From: [REDACTED]
Sent: 28 January 2026 21:12
To: Emily Pickup
Cc: Planning
Subject: 3/2025/1005 | Former Lloyds Bank 7 Church Street Clitheroe BB7 2DD
Attachments: Shop-Fronts-Guide-CCS-16102025.pdf

Re: 3/2025/1005 | Former Lloyds Bank 7 Church Street Clitheroe BB7 2DD

These comments are on behalf of [REDACTED] and relate to the impacts of the proposals on the Non-Designated Heritage Asset (NDHA) of 7 Church Street, and on the character and appearance of the designated Clitheroe Conservation Area.

Sign 1 - Non Illuminated Conservation Fascia Sign - Scale 1:25

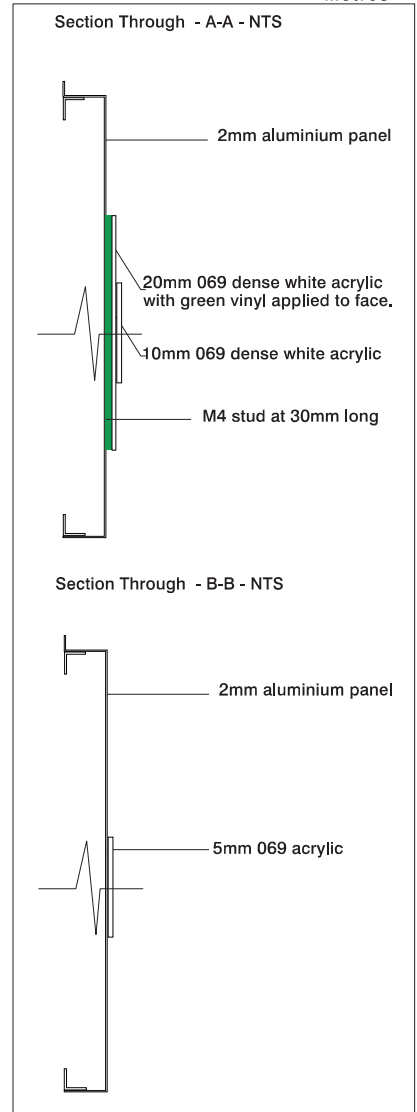
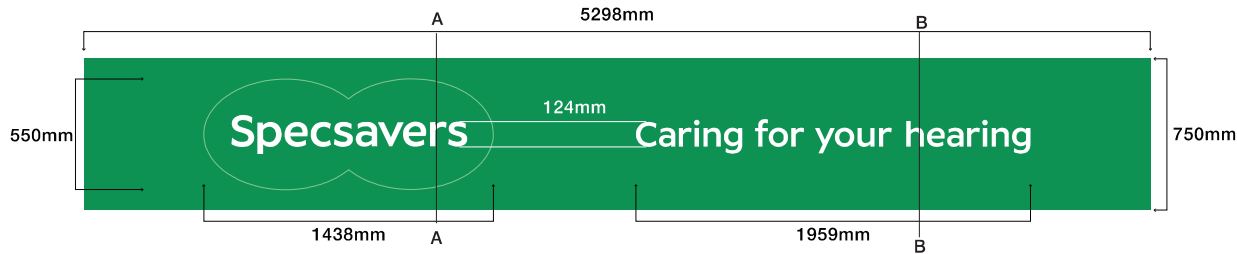
We have concerns over the proposed fascia sign and the vinyl stickers, and their impact on the conservation area. The previous Lloyds Bank signage took the form of individually applied letters, while the new proposed signage would be a large and brightly coloured painted aluminium sign. Individually applied letters are less intrusive while still attracting customers and acting as wayfinding, and previously worked well on this building. As 7 Church Street was originally built as a private residence it does not have a traditional shop front and therefore no logical place for signage, which means a standard fascia sign like the one proposed appears incongruous and distracting. We would urge the applicant to revisit the proposed signage and opt for a more sensitive design that responds to the character of the conservation area and is in keeping with the age and style of the building.

The proposed fascia sign and vinyl stickers in their current form would result in harm to the significance of the NDHA and to the designated Clitheroe Conservation Area. This is contrary to NPPF paragraphs 212, 216 and 219; and to Policy DME4 and Key Statement EN5 of the Ribble Valley Core Strategy, all of which emphasise the importance of conserving the significance of heritage assets and that development in the Clitheroe Conservation Areas should look for opportunities to enhance or better reveal its significance.

Sign 4 - Externally Applied Blank Vinyl - Scale 1:20

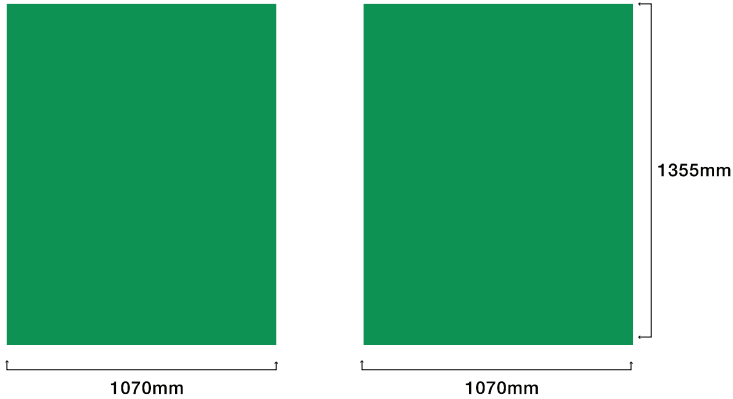
The proposed brightly coloured vinyl stickers on the windows are inappropriate for this location and conflict with the primary goal of preserving the historic character and architectural integrity of the conservation area. As with the signage, we encourage the applicant to seek amended designs that provide an alternative way of obscuring the glass while responding sensitively to the building and its location.
